Report of the Head of Planning and Enforcement

Address 2 & 4 NORTHWOOD ROAD HAREFIELD

Development: Change of use from retail (Class E) to Residential (Class C3) (Application under Class MA, Part 3 of Schedule 2 to the Town and Country Planning (General Permitted Development) (England) Order 2015 (as amended)).

LBH Ref Nos: 24375/APP/2022/428

SITE PLAN - PROPOSED
1:200

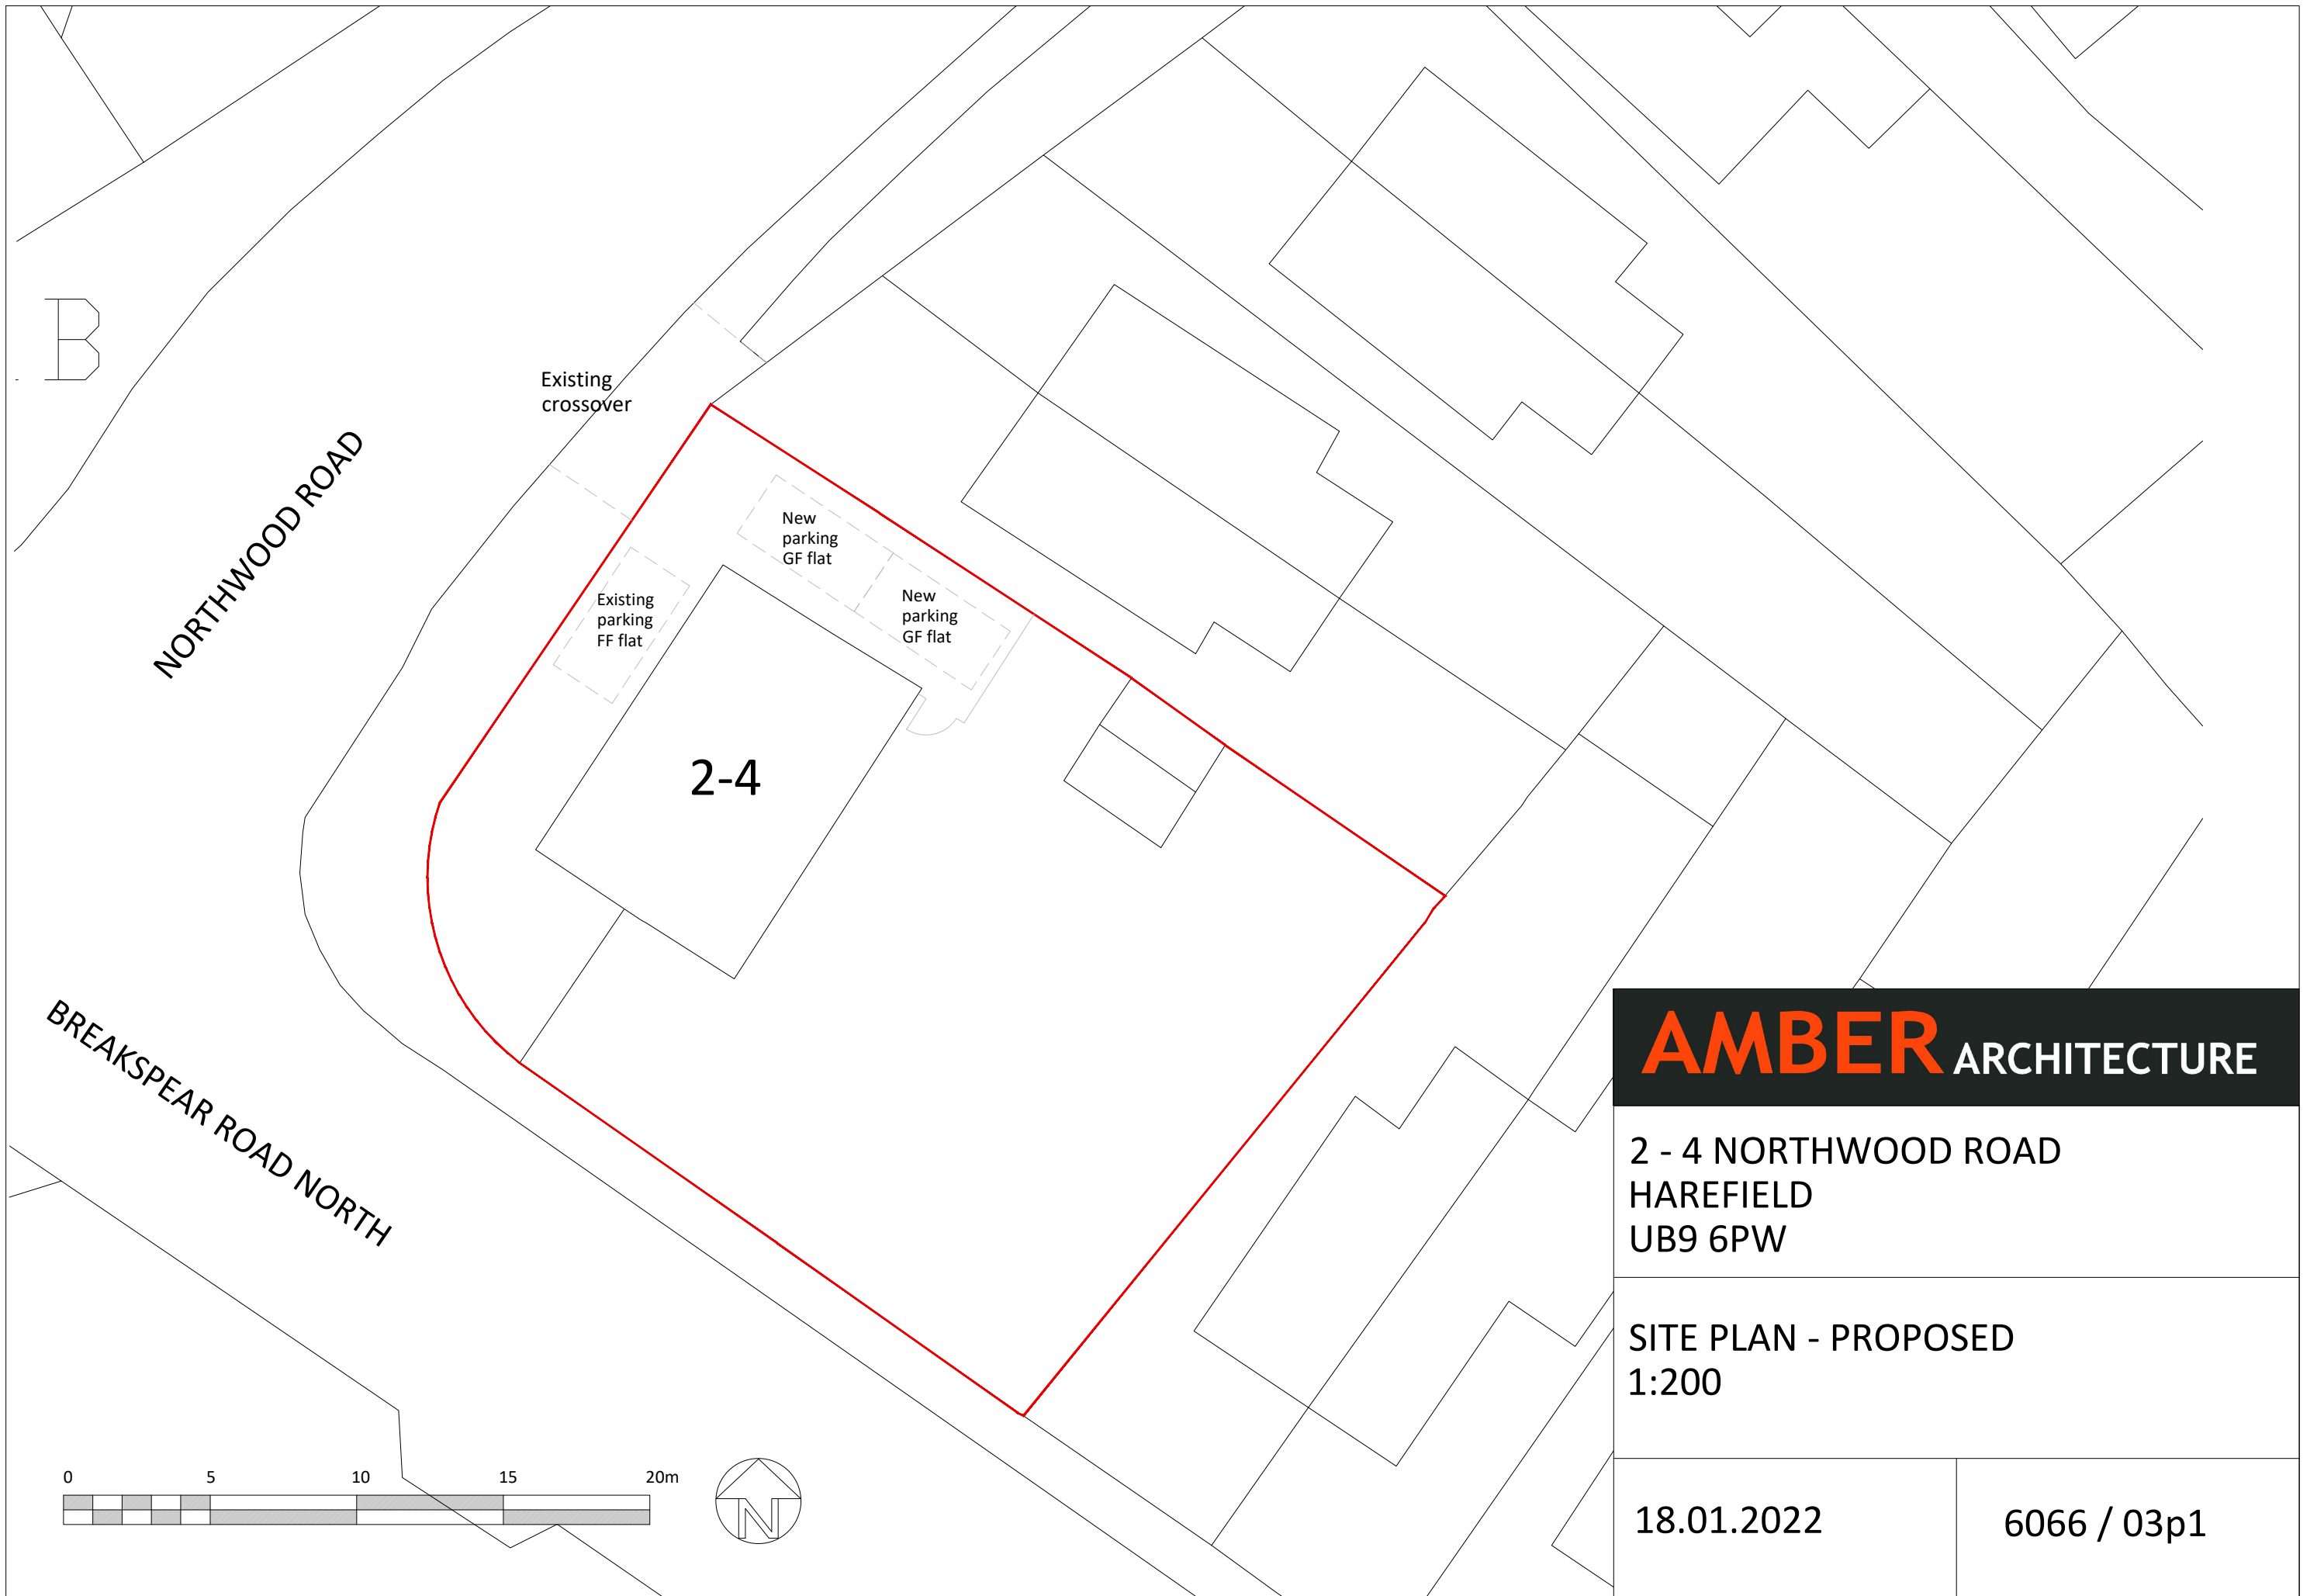
Appendix C, Table 1 of the Hillingdon Local Plan: Part 2 - Development Management Policies (2020) requires 3 bedrooms flats to have a maximum of 2 on-site car parking spaces. The submitted site plan shows that two on-site car parking spaces would be allocated to the proposed flat and one car parking space would be allocated to the existing first floor flat. The proposed on-site car parking provision would comply with the Council's adopted car parking standards. It is therefore considered that the proposal would not unacceptably exacerbate the demand for street parking.

No cycle store details are shown on the submitted drawings. However, full details (including the location, dimensions and design of the cycle store) could have been secured by way of a condition, had this application been recommended for approval. It is recommended that any resubmission includes these details.

No refuse/recycling details for the proposed flat have been shown on the submitted drawings. However, full details (including the location, dimensions and bin store screening) could have been secured by way of a condition, had this application been recommended for approval. It is recommended that any resubmission includes these details.
